CITY OF ALBUQUERQUE

RE: **Broadstone Highlands East Block
Grading and Drainage Plan
Engineer's Stamp Date: 2/7/18
Hydrology File: K15D034C**

Re: Broadstone Highlands East Block / Hydrology File K15D034C

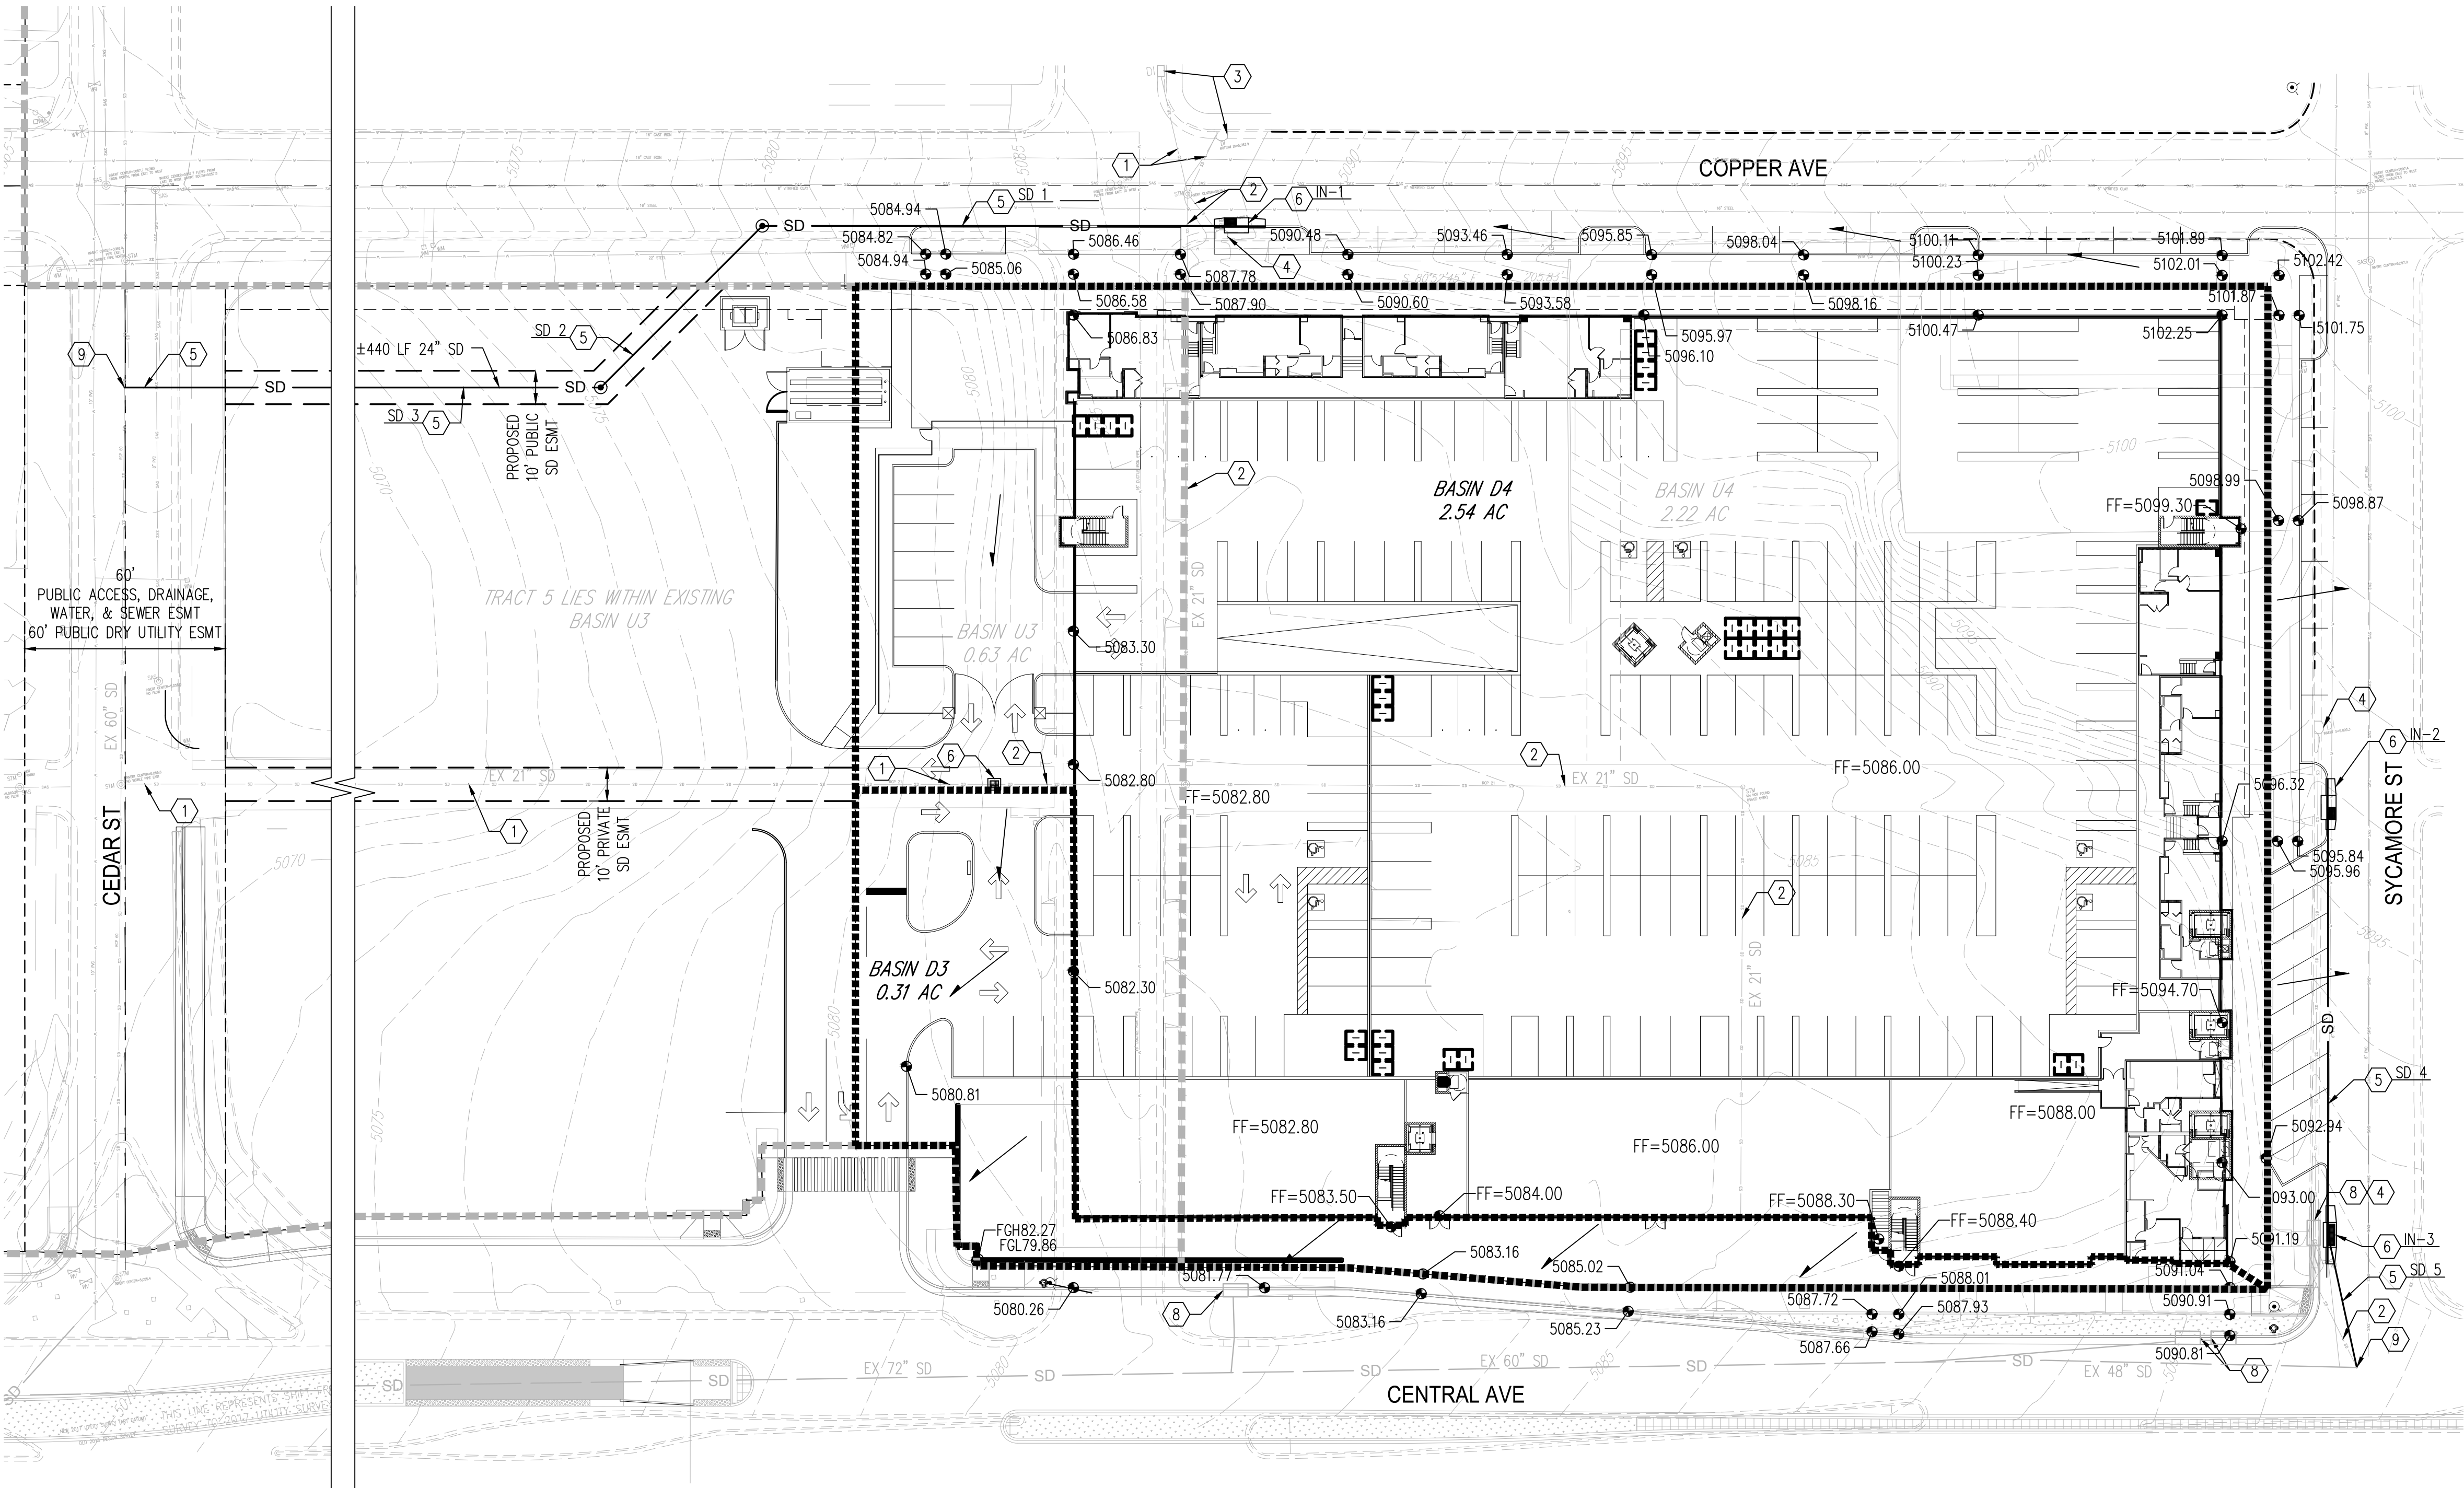
1. Include an off-site subbasin map, including topographic data.
Response: Please see the "Supplemental Information" Exhibit which indicates the offsite basins contributing to the inlets within Sycamore St and Copper Ave.

2. Clarify roof drainage and show on plans.
Response: At this time, the roof drains are conceptual but intend to drain to the existing 21" within Tract 5.

3. Label all Public vs. Private drainage improvements and ensure all improvements in the public ROW are on the infrastructure list.
Response: The public and private drainage infrastructure improvements have been labeled on the Conceptual Grading and Drainage Plan. The public infrastructure improvements have been included on the infrastructure list.

4. Clarify how the connections to existing storm drain will be made (keyed note 9). If there is no existing manhole to connect to, a new manhole will need to be built and included on the infrastructure list.

5. The new public storm drain easement (recorded) needs to be included on the infrastructure list. Provide a trenching prism at deepest point to evaluate the required width. The width will need to be at least 20' per DPM Ch.22, Section 6, Part C.

Response: Keyed note 9 has been expanded on regarding the type of connection to the existing storm drain. The infrastructure list includes all associated manholes and inlets within the footnote.

Response: The public storm drain easement will be included on the infrastructure list. A conceptual trenching prism has been provided on the "Supplemental Information" Exhibit to indicate that the minimum 20' wide easement will suffice for this storm drain at the deepest point.
